Rezoning Transportation Analysis
Petition Number: Insert Zoning Petition #2021-056
General Location Identifier: 04105416

Revision Log:

Date	Description
05-27-2021	First Review (EL)

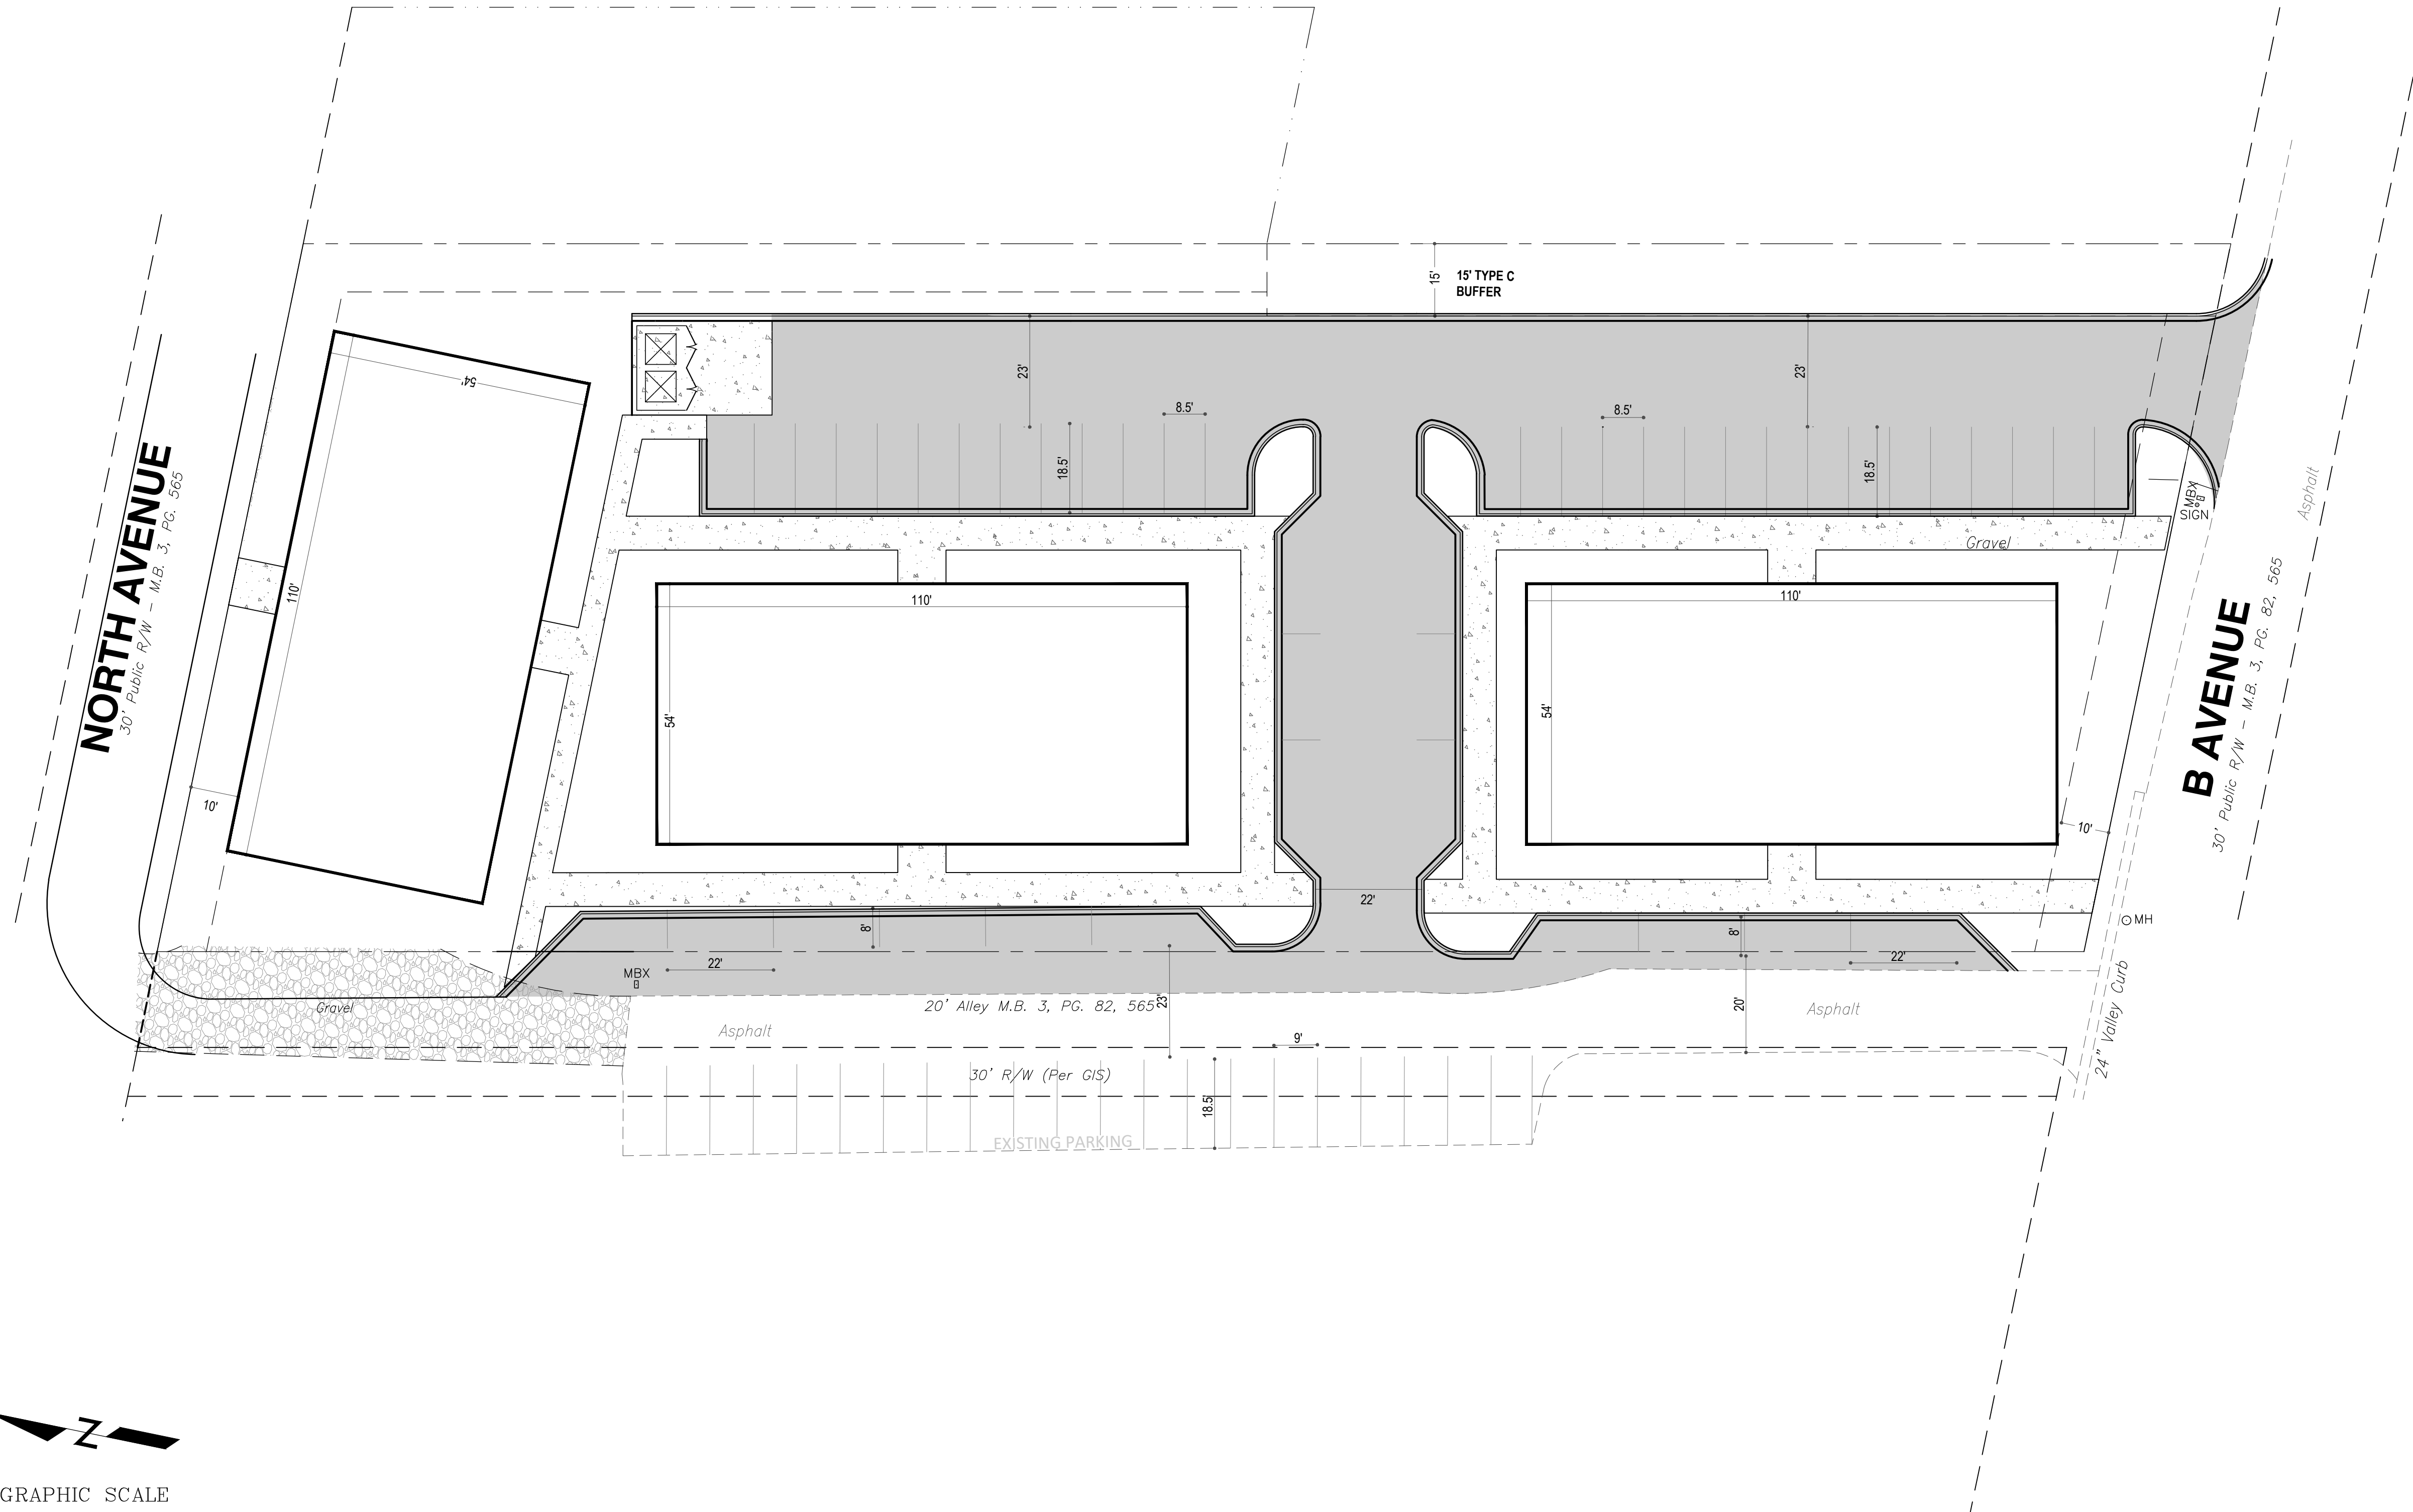
1. **Curblines:** The proposed zoning district has a setback measured from back of the existing or proposed future curblines.
 - a. **B Avenue:** Location of 2'-6" curb and gutter needs to be installed 13-feet from B Avenue road centerline per CLDSM standard detail number *U-02 – Local Residential Medium Street Typical Section*.
 - b. **North Avenue:** Construct a CLDSM standard detail number *U-02 – Local Residential Medium Street Typical Section* (for the portion highlighted in red) along the property frontage of North Avenue. Planting strip and sidewalk is only required along this rezoning site's property frontage.

- c. **Alleyway/Paper Right of Way:** Construct a CLDSM standard detail number *U-03 – Local Residential Wide Street Typical Section* (for the portion highlighted in blue) along the property frontage of alleyway/paper right of way. 8-foot planting strip and 8-foot sidewalk is only required along this rezoning site’s property frontage since DUA is greater than 12.

Label and dimension the curb and gutter from the centerline for each road on the site plan.

3. Revise site plan and conditional note(s) to commit to dedicate 28-feet of public right-of-way from the North Avenue and B Avenue road centerlines. The site plan shall label and dimension the right-of-way from the road centerline, per CLDSM standard detail number *U-02 – Local Residential Medium Street Typical Section*.

4. Revise site plan and conditional note(s) to commit to dedicate 35.5-feet of public right-of-way from the alleyway centerline, if public right of way is already platted. The site plan shall label and dimension the right-of-way from the road centerline, per CLDSM standard detail number U-03 – *Local Residential Wide Street Typical Section*. If this is confirmed to only be a 20-foot wide alleyway, coordinate with CDOT to determine the appropriate requirements.

5. Revise site plan and conditional note(s) to commit to construct an 8-foot planting strip and 8-foot sidewalk on all public street frontages per Chapter 19 / Chapter 20 of the City Code and the Charlotte WALKS Council-adopted policy. 8-foot sidewalk is needed since more than 12 dwelling units per acre is proposed. The site plan shall label and dimension both items from the back of curb and gutter and road centerline.

- 6. Revise site plan and conditional note(s), including Site Plan Conditional Note 3.a, Access, Transportation, and Improvements to extend the Residential Wide typical section on the alleyway / paper right of way to North Avenue.

- 7. Revise site plan and conditional note(s) to commit to construct two PROWAG ramps at the alleyway / paper right of way intersections with North Avenue and B Avenue.

- 8. A site plan note(s) specifying dedication and fee simple conveyance of all rights-of-way to the City before the site's first building certificate of occupancy is issued is needed. CDOT requests rights-of-way set at 2' behind back of sidewalk where feasible.
